## Engineers Comments Regarding Surface Water Drainage

| <b>Application Reference:</b>   | WA/50/25/DOC                                                                                                                                                                                                                                             | <b>Reviewer Reference:</b> | ADC/EXT4   |
| <b>Site Name:</b>               | Fleurie Nursery Lake Lane Barnham PO22 0AL                                                                                                                                                                                                               |                            |            |
| <b>Application Description:</b> | Approval of details reserved by condition imposed under reference WA/75/20/PL relating to condition number 3 - surface water drainage scheme, condition number 4 - surface water drainage system and condition number 7 - surface water drainage scheme. |                            |            |

Drainage
SE Glass exceedance
Bund area and level

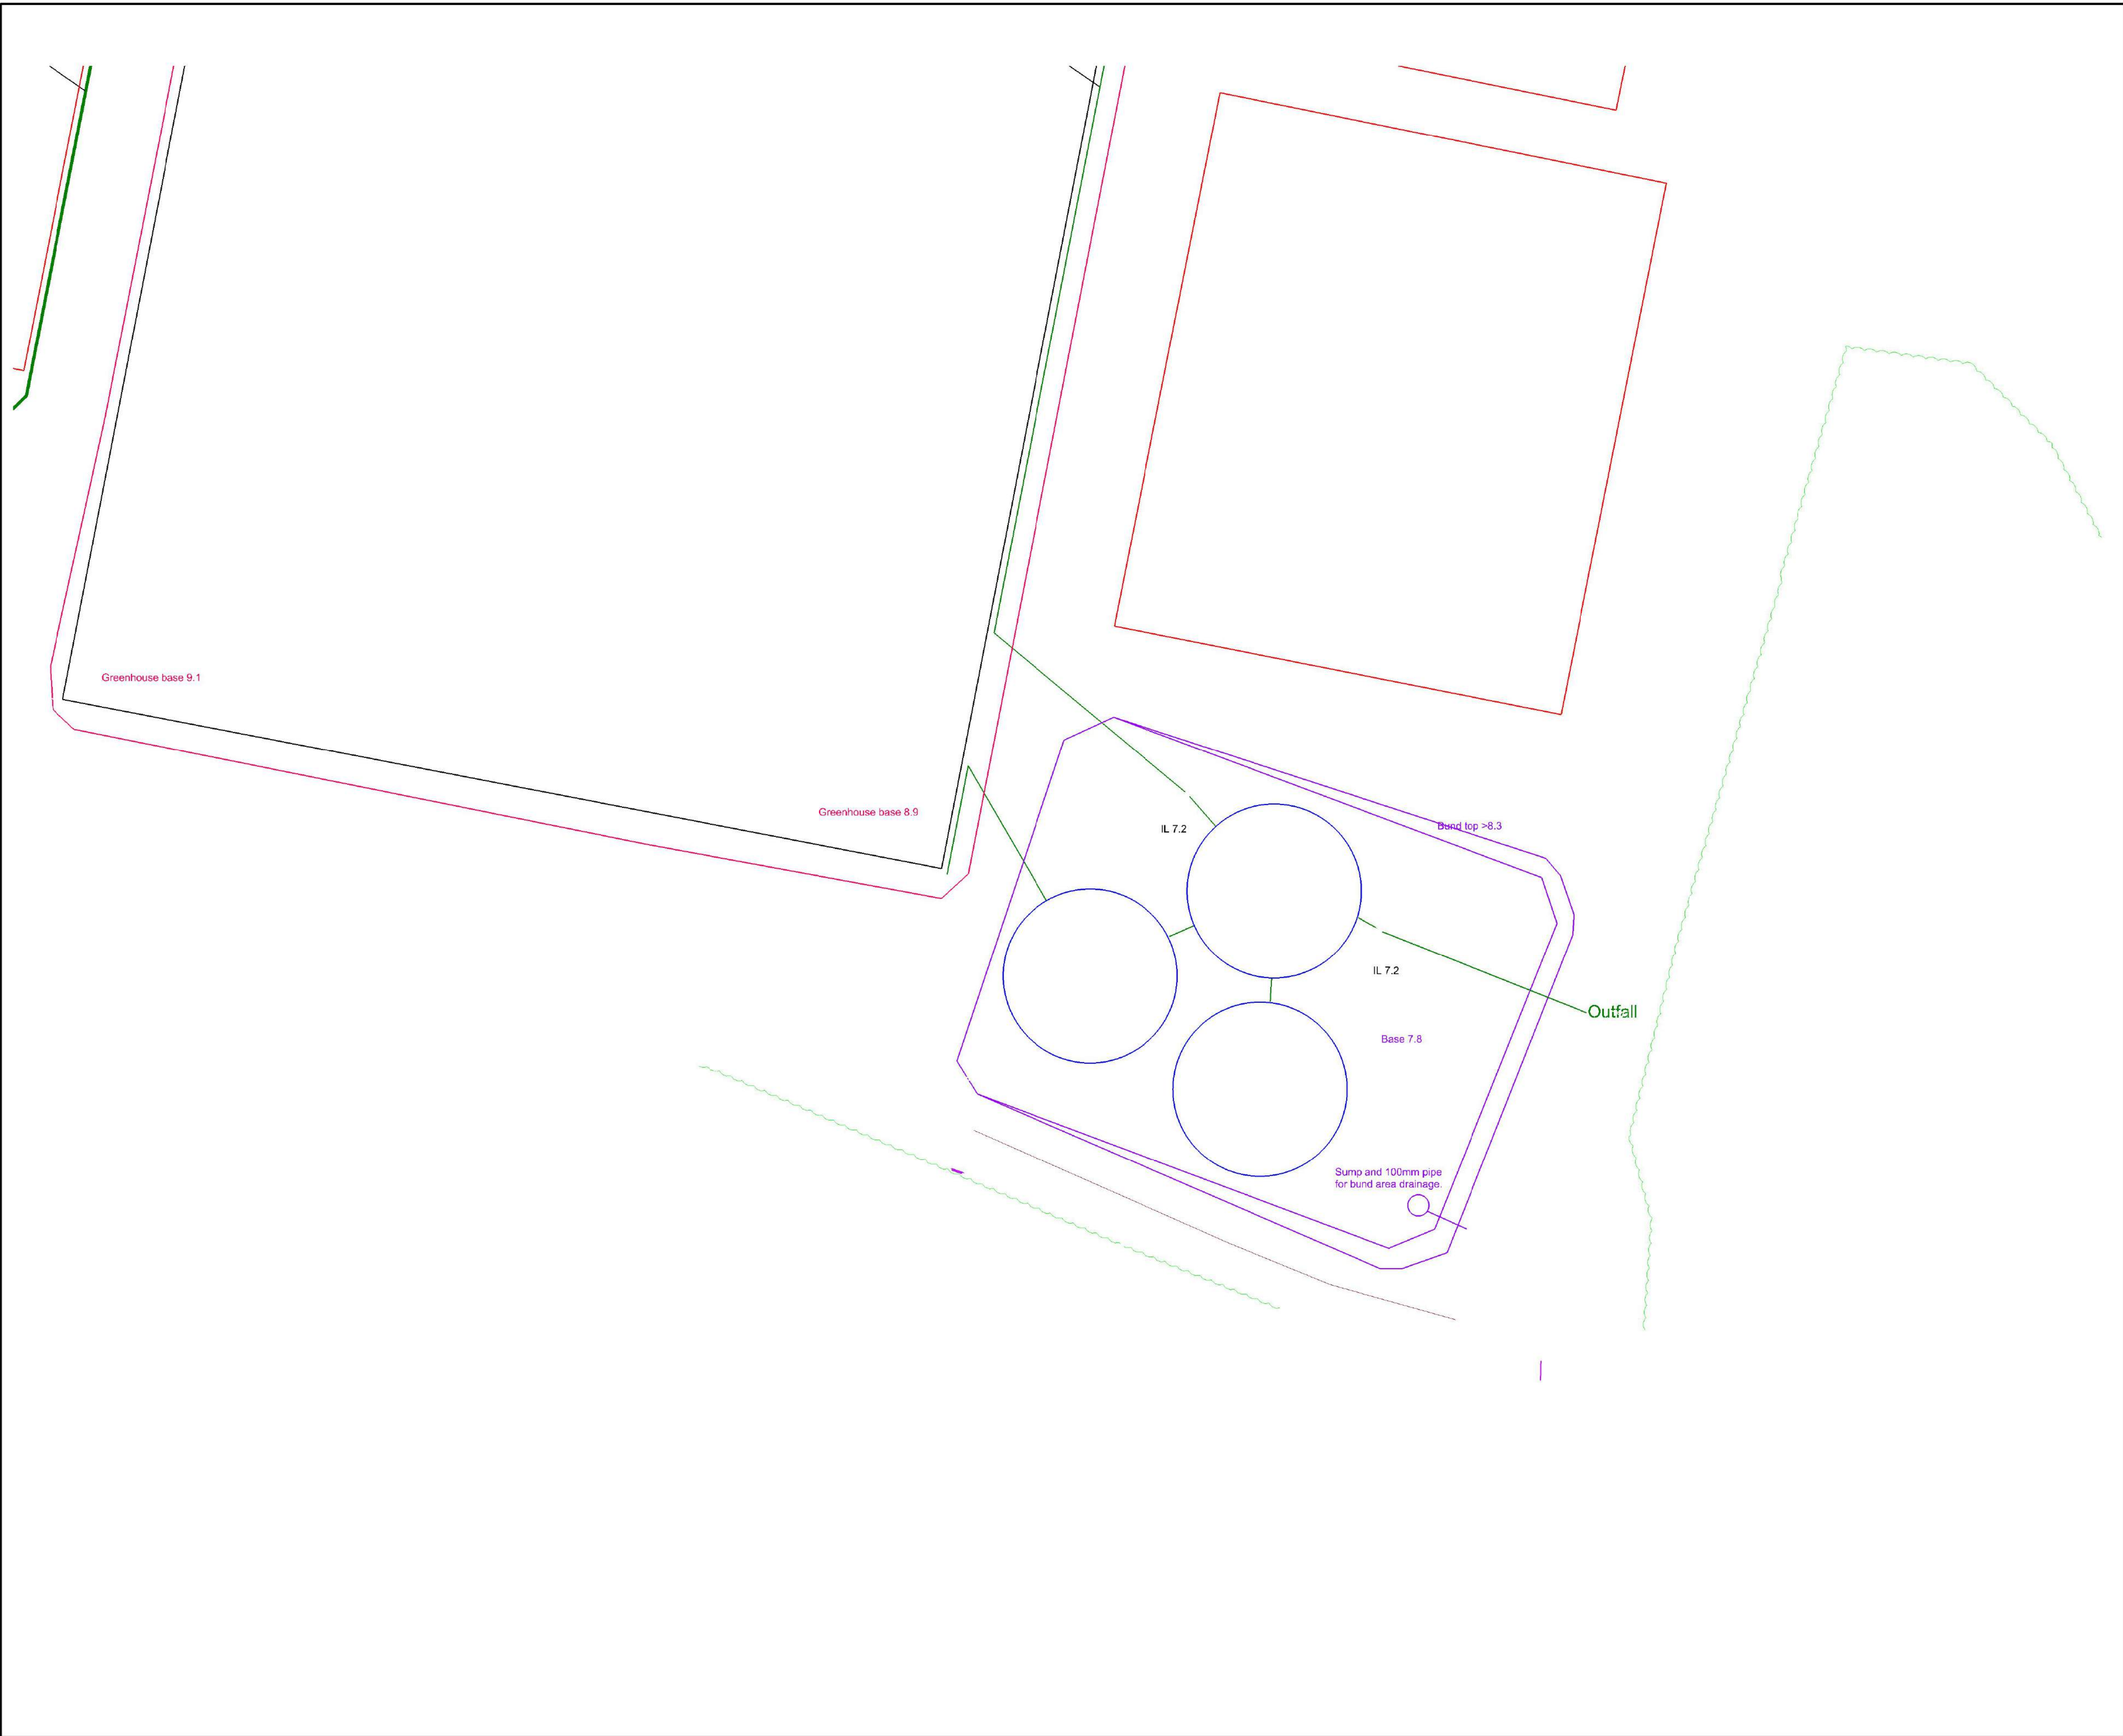
|                            | ADC Drainage Comments                                                                                                                                                                                                                                                                                                              | Designer Response |  |  |  |
|----------------------------|------------------------------------------------------------------------------------------------------------------------------------------------------------------------------------------------------------------------------------------------------------------------------------------------------------------------------------|-------------------|--|--|--|
| 5                          | The exceedance flow layouts are unclear. Further information is required on areas of temporary ponding, flow directional arrows etc...                                                                                                                                                                                             |                   |  |  |  |

Outfall A (North)

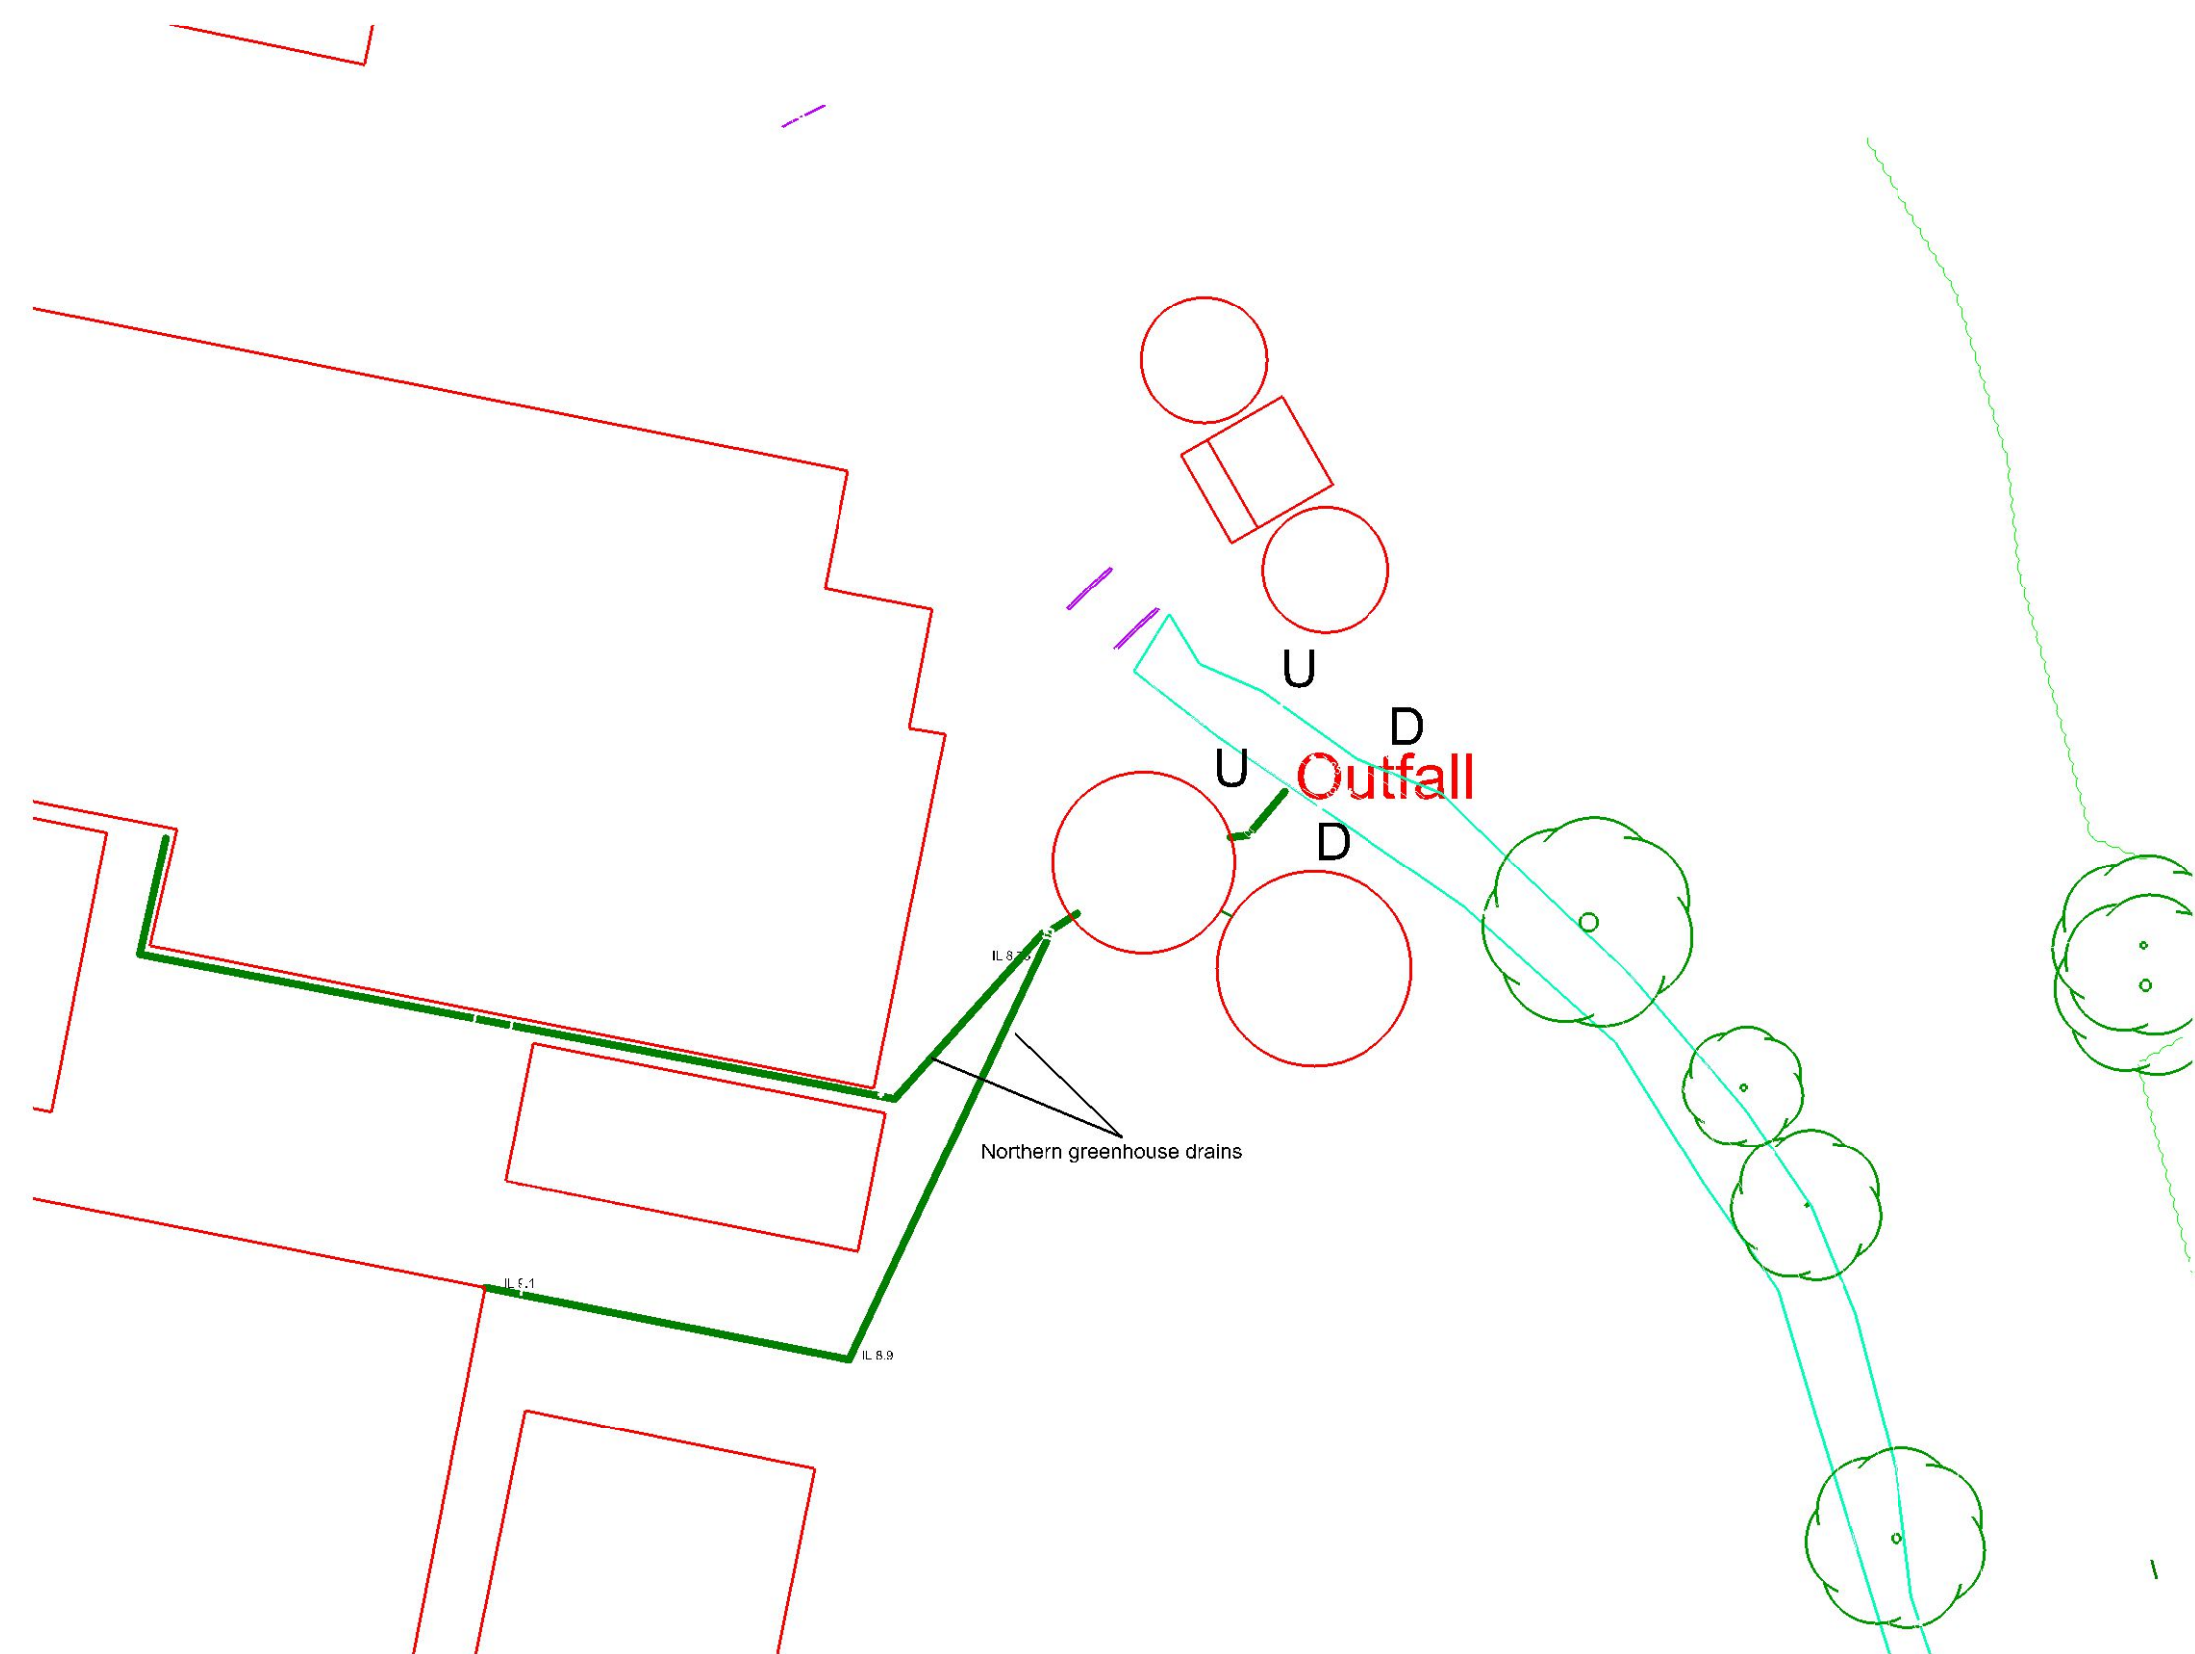
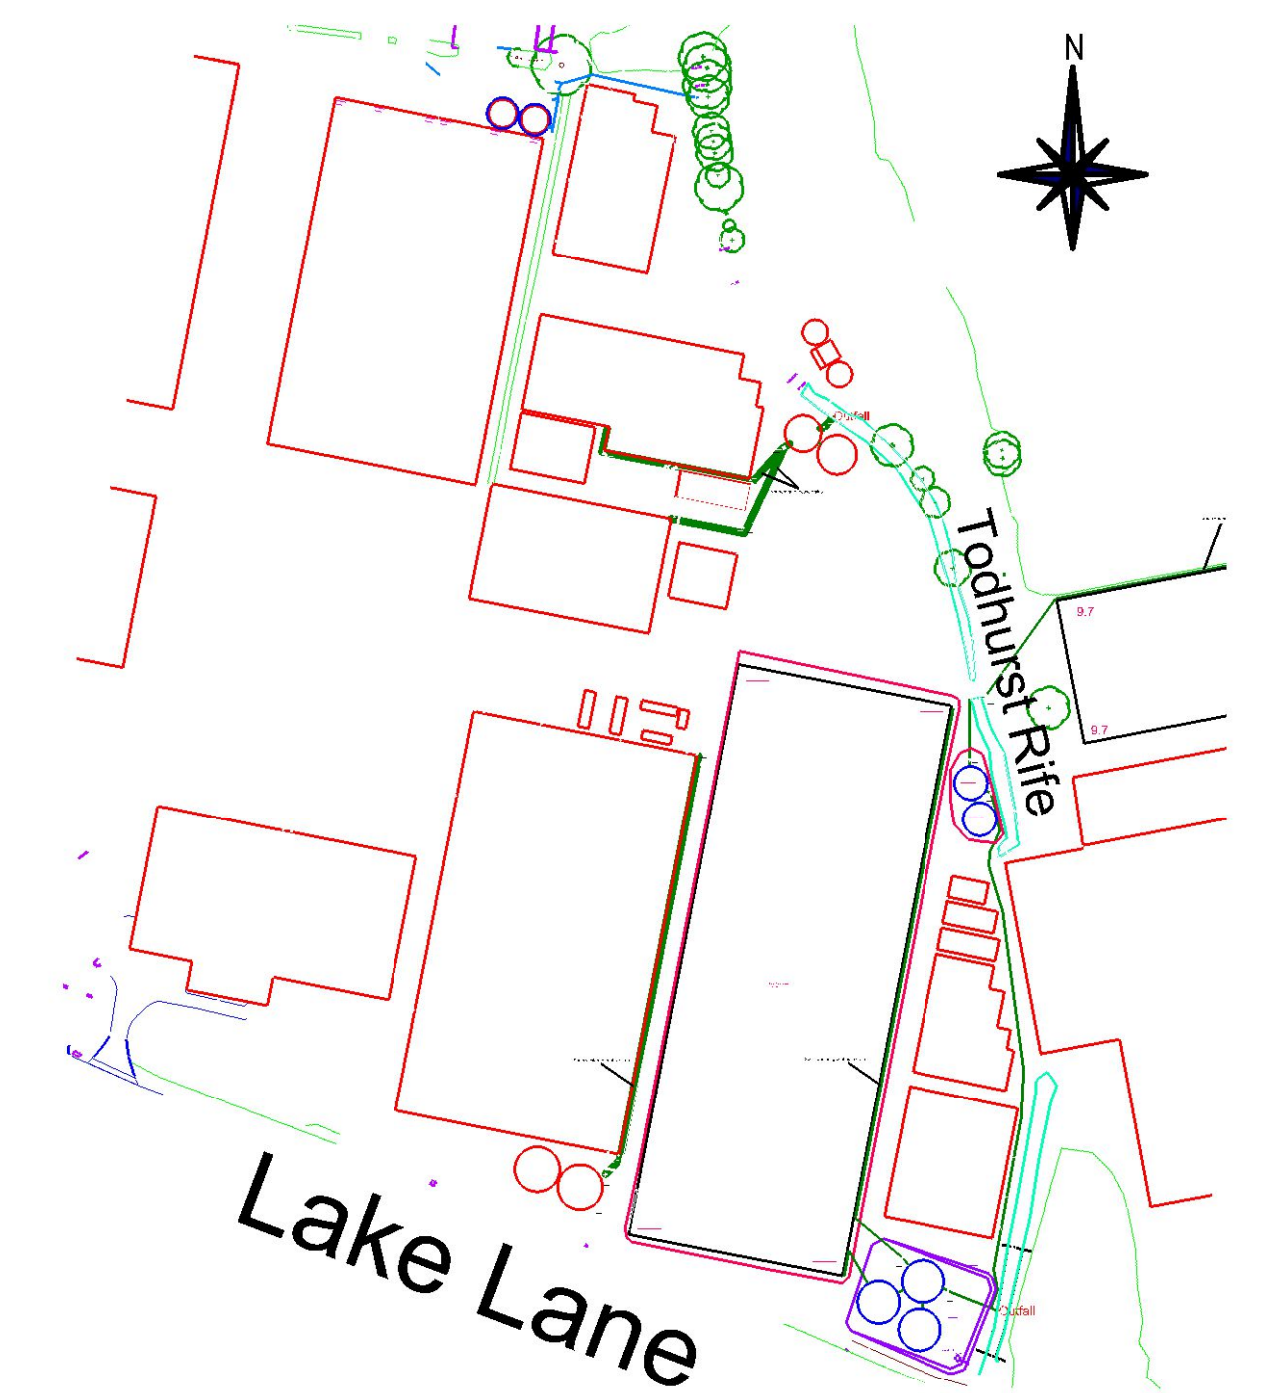
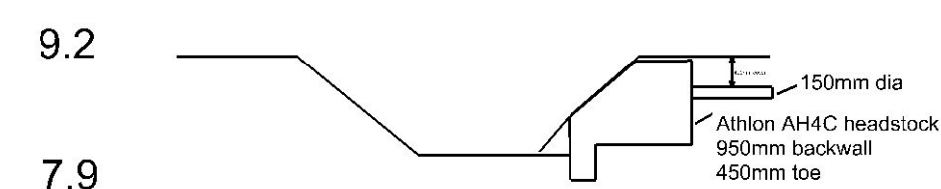
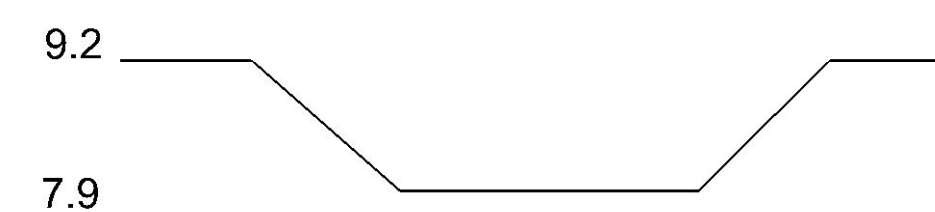
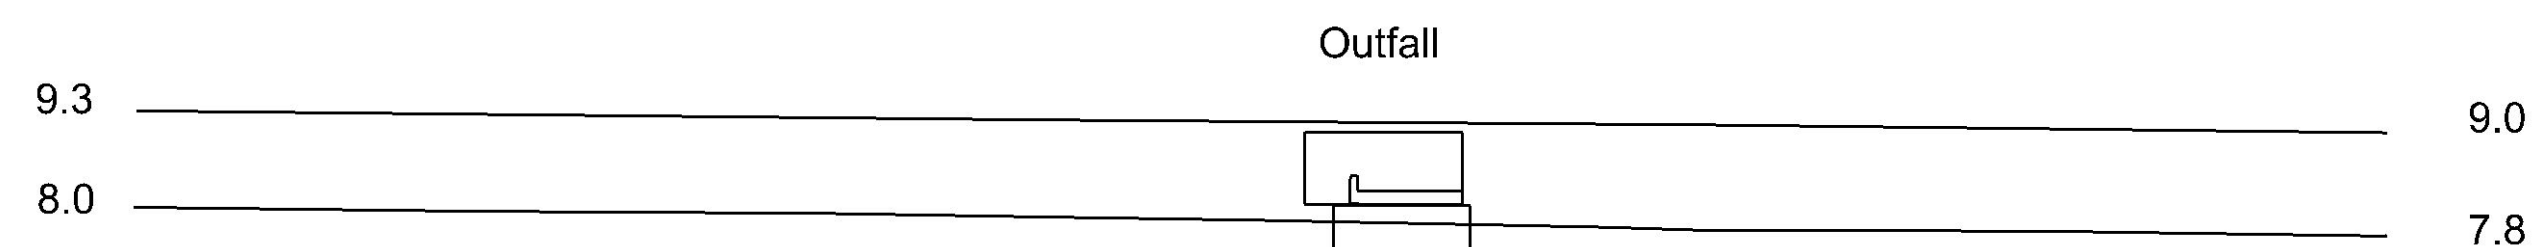
|                            | ADC Drainage Comments                                                                                                                                                                                                                                                                                                              | Designer Response |  |  |  |
|----------------------------|------------------------------------------------------------------------------------------------------------------------------------------------------------------------------------------------------------------------------------------------------------------------------------------------------------------------------------|-------------------|--|--|--|
| 6.                         | The headwall outfall details provided are insufficient and do not provide any construction details on specific type of headwall, bedding details, interface with the existing earthworks etc..                                                                                                                                     |                   |  |  |  |
